Subject: RE: FW: Response To Application Number A/26/21/RES at Land west of Brook Lane and South of A259 Angmering BN16 3JL

We write in relation to application A/26/21/RES.

176-002

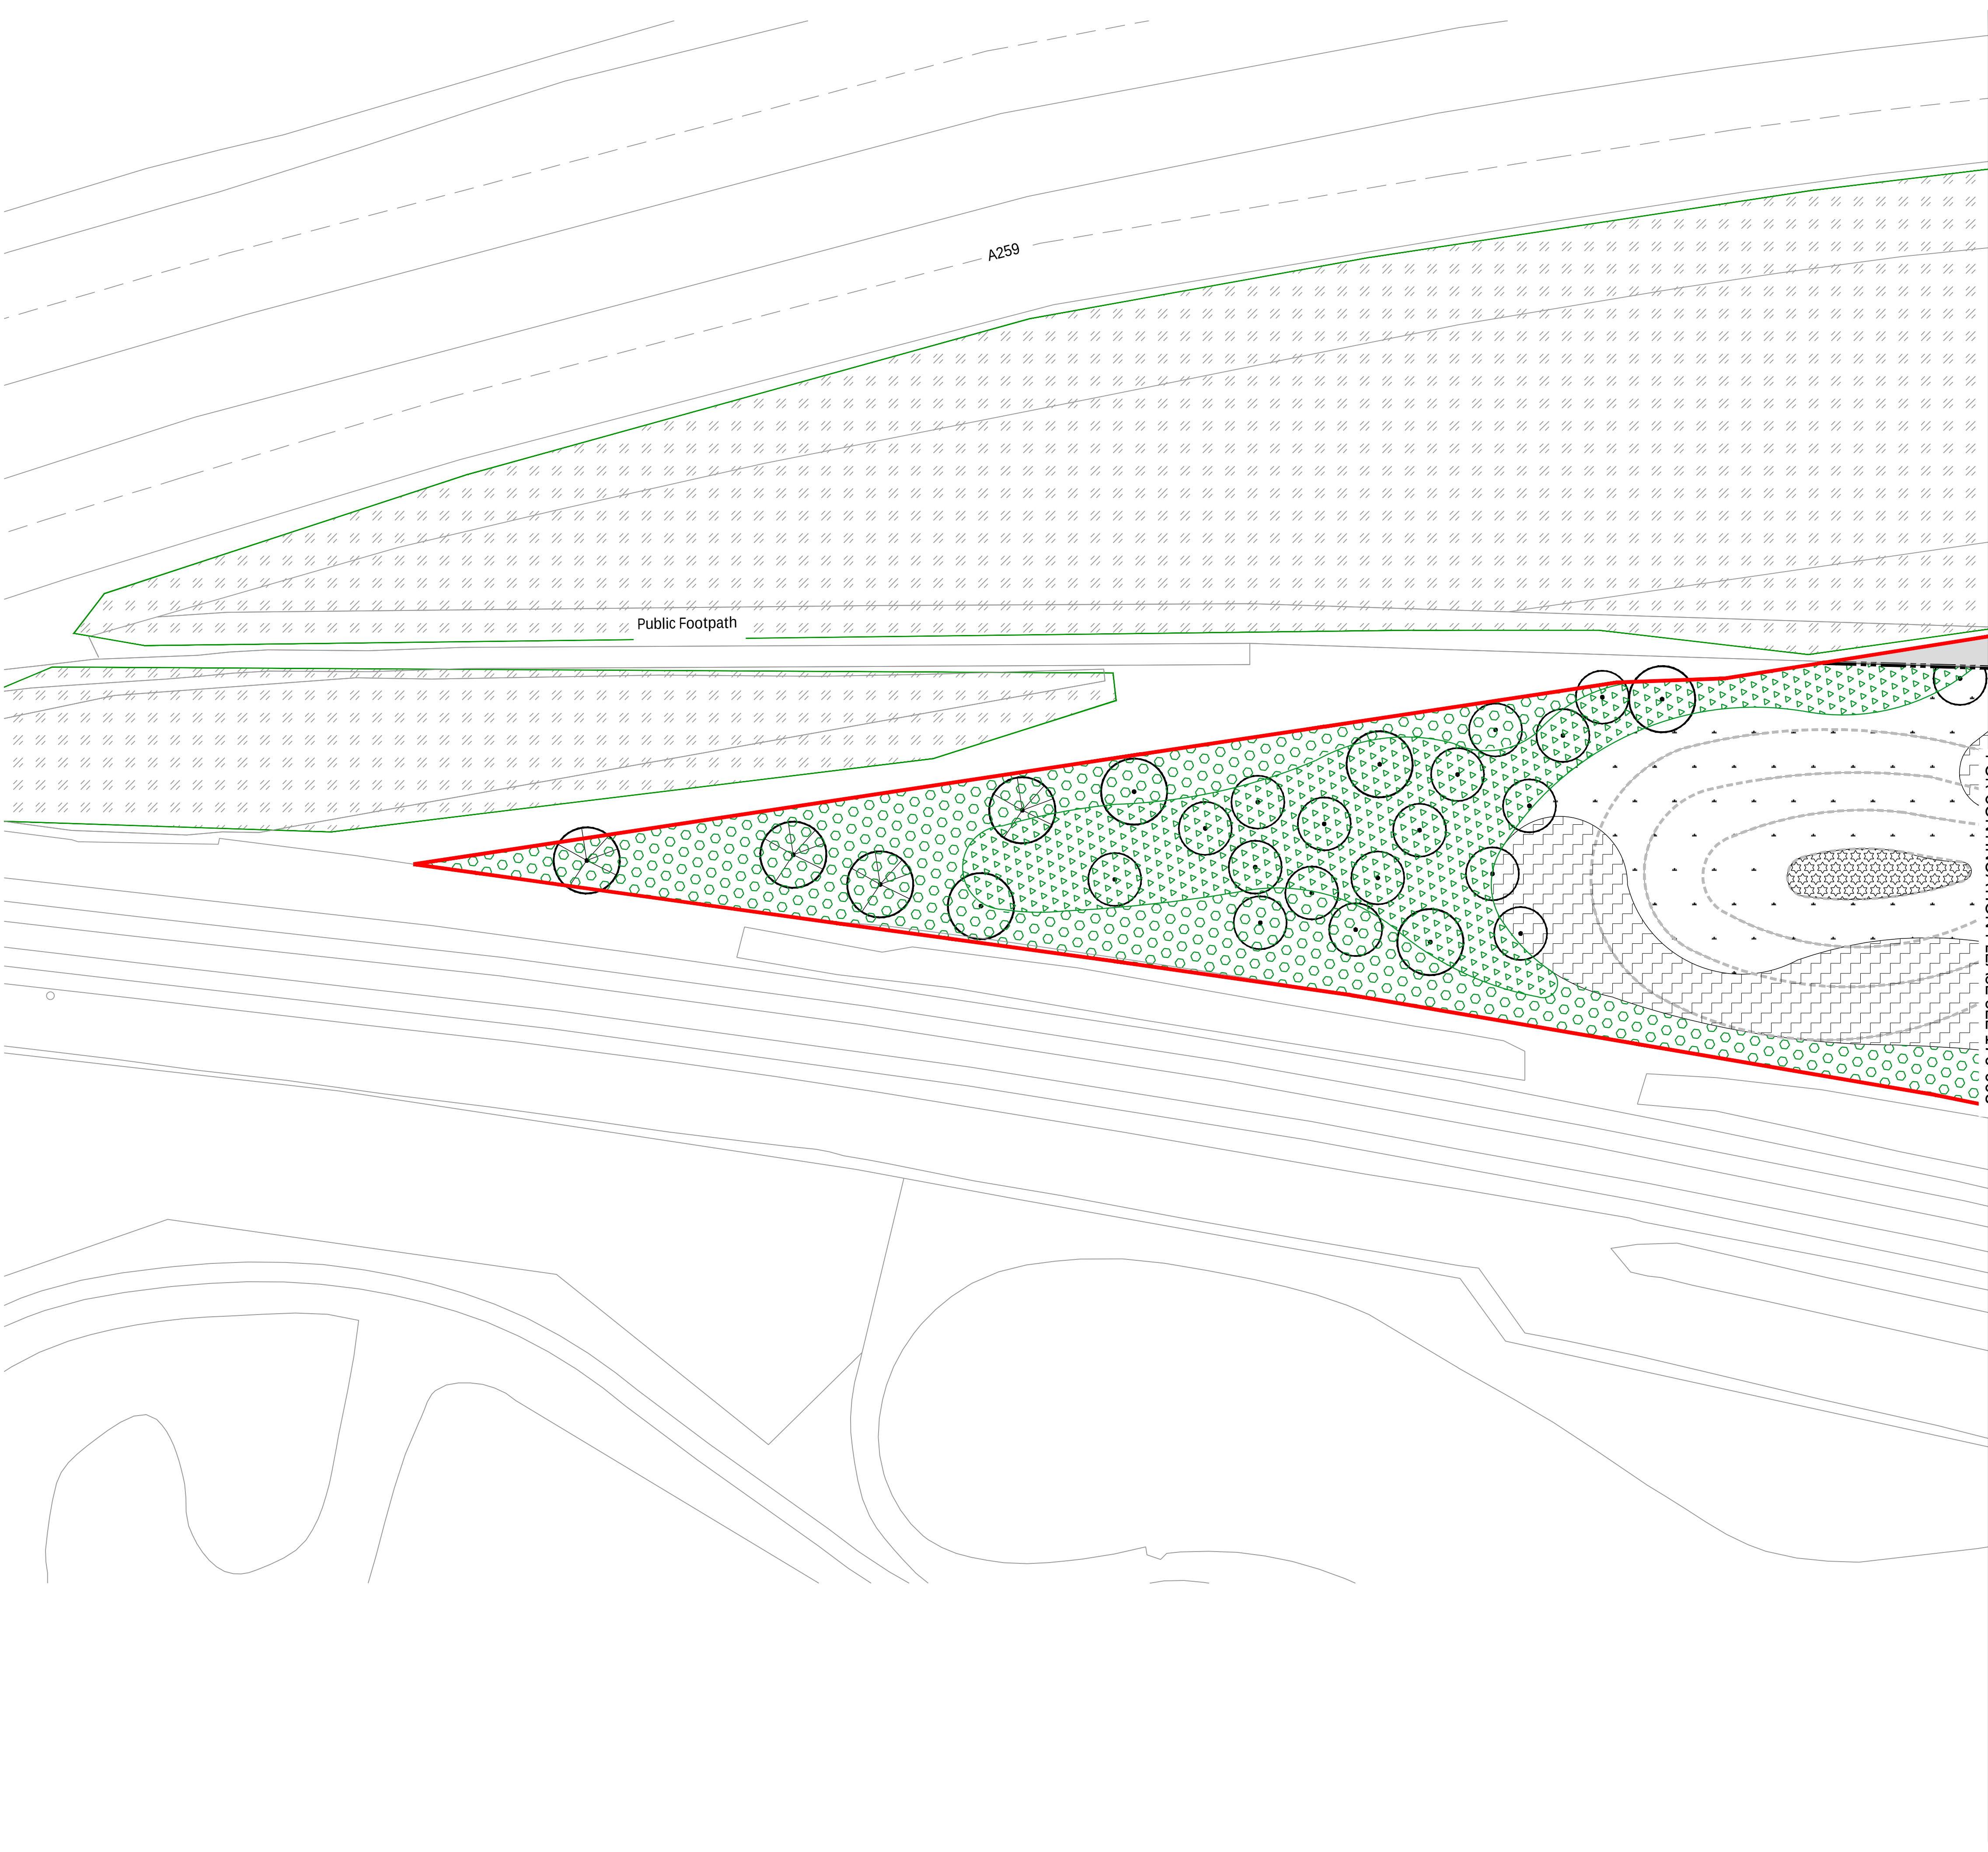
I have spoken to County Highways today. You need to demonstrate that there is sufficient width for the pedestrian right of way to facilitate permissive use by cyclists. This would need to be indicated on a plan with appropriate wording/detailing to show that the path is of sufficient width and could facilitate use by cyclists to one side without endangering/conflicting with pedestrian use.

Please see attached plan provided by Mayer Brown that illustrates the permissive path for cyclists and pedestrians through the site.

As you will see there is a short section where the footpath narrows to 2.0m which would not be suitable for cycling, however cyclists could use the road at this point if suitable signage is provided. The Cycle Infrastructure Design Guidance (LTN 1/20) notes that for paths with less than 300 cyclists and 300 pedestrians per hour, a 3.0m shared footway/cycleway is acceptable. And that *"Where motor traffic flows are light and speeds are low, cyclists are likely to be able to cycle on-carriageway in mixed traffic"*.

On the basis of the above we consider the proposals meet the requirements set out on the LTN 1/20 guidance. If helpful further information could be required during the detailed design of the project.
